KITTITAS COUNTY DEPARTMENT OF PUBLIC WORKS

MEMORANDUM

DATE: October 10, 2016

SUBJECT: Filbert Estates Short Plat SP-15-00004

SP-15-00004

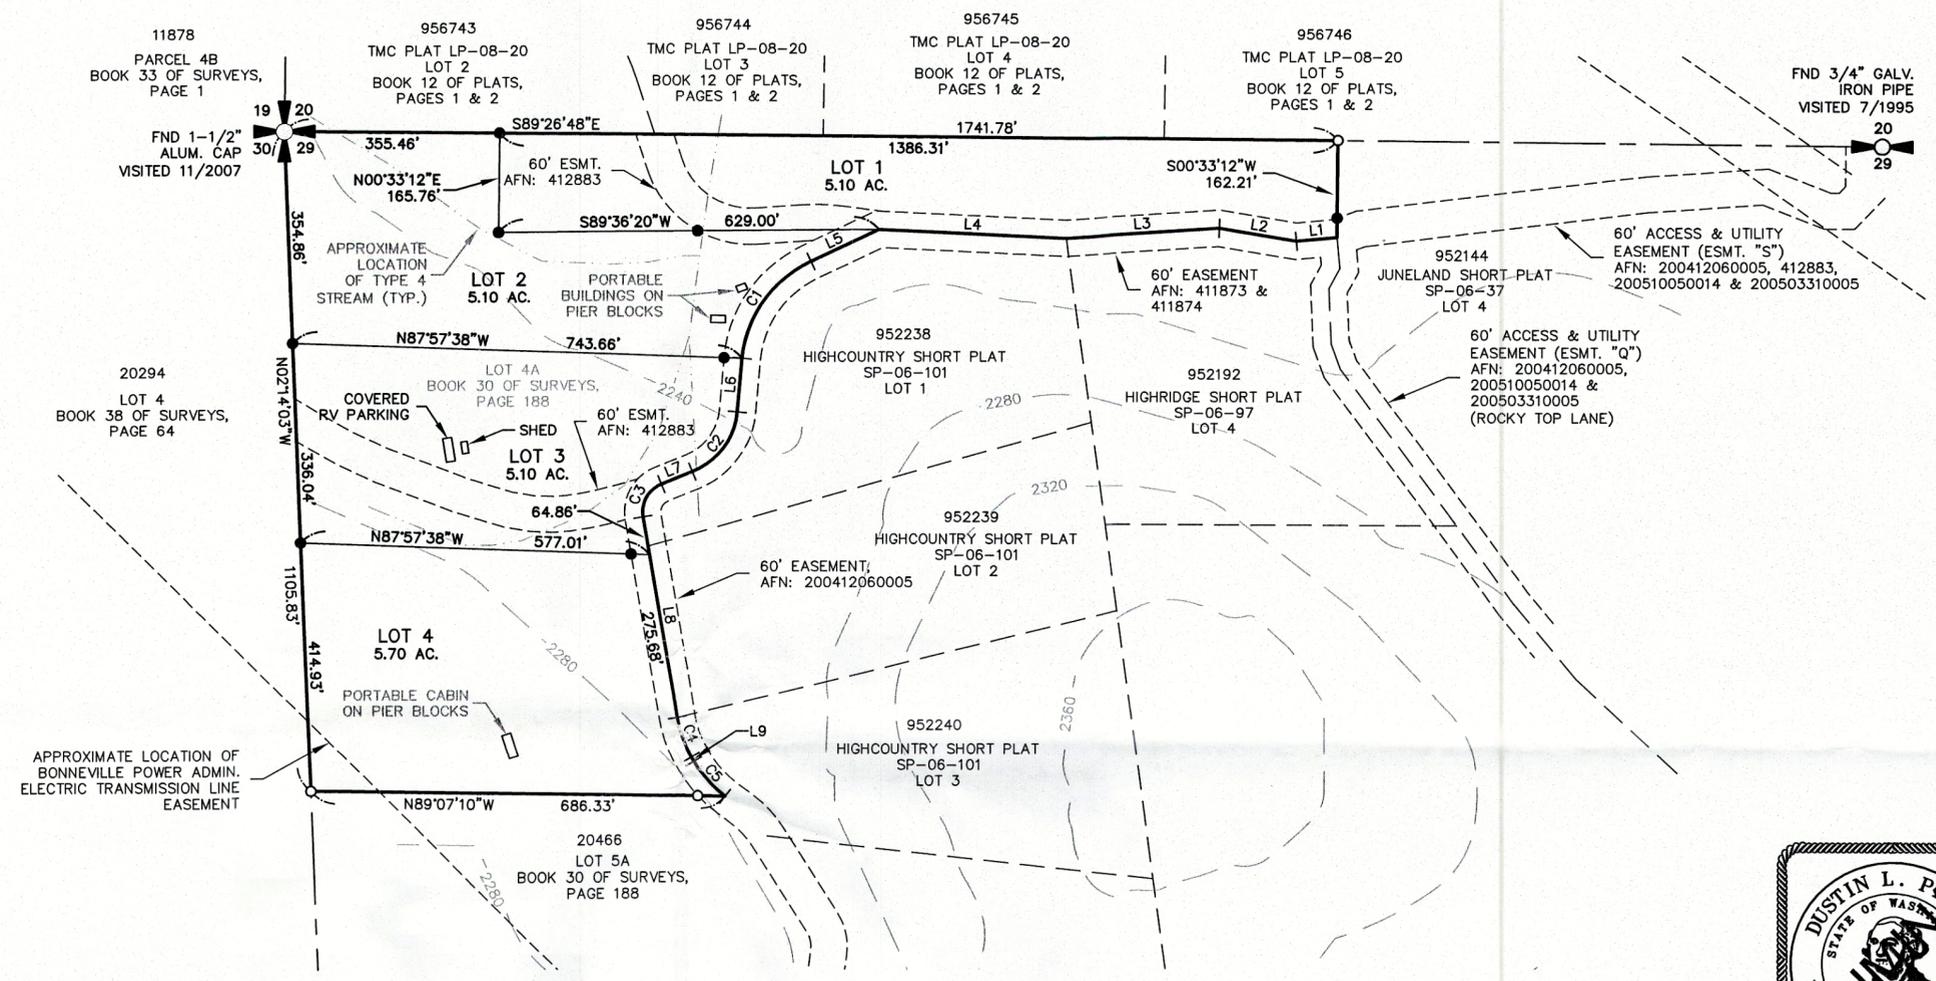
3. Canal Bridge: The existing 14 foot wide bridge over the canal must be brought up Kittitas County Road Standards 9/6/05 edition.
4. Easements: All access easements must be recorded and presented to Public Works prior to final approval. The minimum easement width for all easements serving this property is 60'.

5. Private Road Improvements: Filbert Road from Nelson Siding Road to the required cul-de-sac at the end of lot 4, shall be constructed as a Low-Density Private Road. See Kittitas County Road Standards, 9/6/05 edition.

- a. Access easements shall be a minimum of 60' wide. The roadway shall have a minimum width of 20', with 1' shoulders, for a total width of 22'.
 - b. Minimum centerline radius will be 60'.

- c. The surface requirement is for a minimum gravel surface depth of 6”.
 - d. Maximum grade is 12%.
 - e. Stopping site distance, reference AASHTO.
 - f. Entering site distance, reference AASHTO.

- j. All easements shall provide for AASHTO radius at the intersection of county road.
 - k. A paved apron shall be constructed at the intersection of the proposed private intersection and the county road right of way.

6. Cul-de-Sac: A cul-de-sac turn-around having an outside right-of-way or easement diameter of at least 110 feet shall be constructed at the closed end of all dead-end roads serving 3 or more lots. The driving surface shall be at least 96 feet in diameter. Cul-de-sacs must also conform to the requirements specified by the 2006 International Fire Code. Contact the Fire Marshal regarding any additional cul-de-sac requirements.
